Project: Permit #2012-069
Re: Intake Comments

Richard Flake Architect
RF Architecture

**SITE PLAN DRIVEWAY OPTION #2**

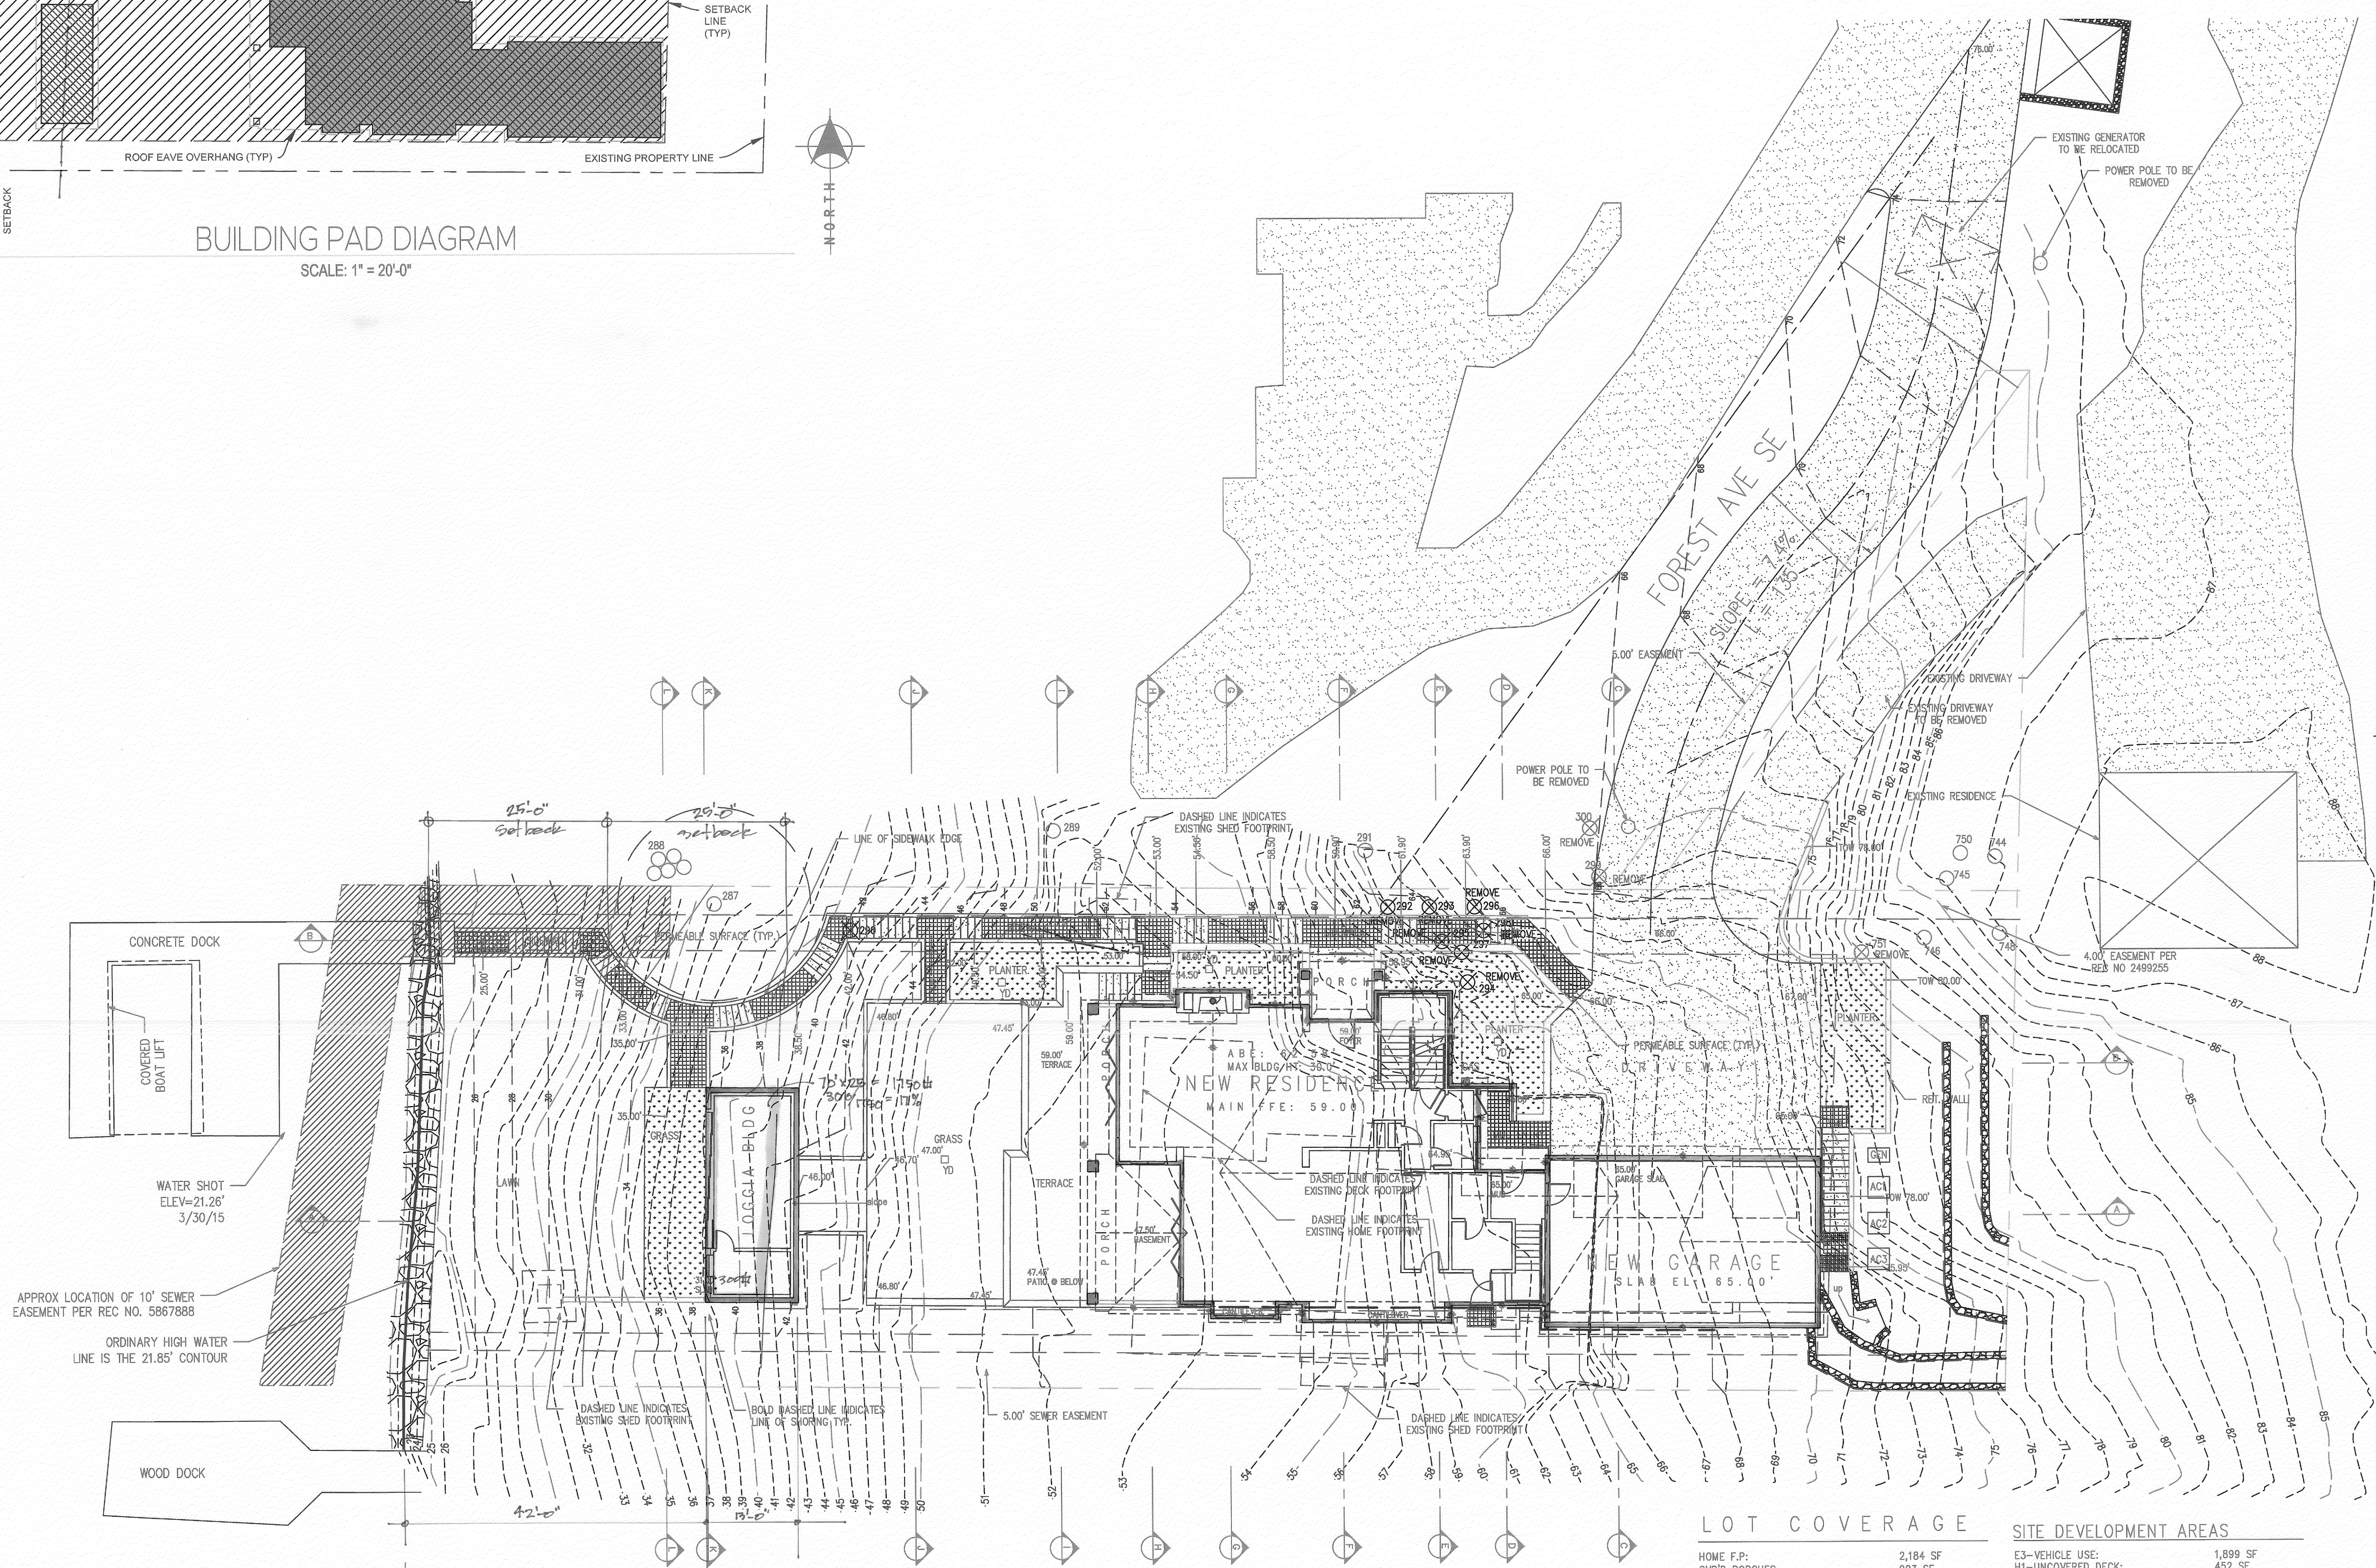
4. Please see Drainage report for complete upload. (this one as well)
5. ire: Please see attached document from prior pre-app where Ruji denied direct access from Forest avenue direct. This is per our discussion recently with Stephen Mair on his suggestion. The 16' wide version of a drive exceeds our impervious surface limitations as the code is being applied. We have revised our Sheet A-1.1 to reflect our best design solution in order to reach code approval.

6. Planning:
 - Our property is zoned R-15 and please see notes added to Sheets A-0.1 & A-1.1.
 - See pad outline added on Sheet A-1.1.
 - See shoreline setbacks re-identified on Sheets A-1.1.

- See new landscape planting plan in shoreline area per Sheet L-1.1
 - See revised sheet A-1.1 and please see survey depicting easements.
7. Planning:
 - Please see notes added to Sheets A-7.1, A-7.2 & A-7.3.
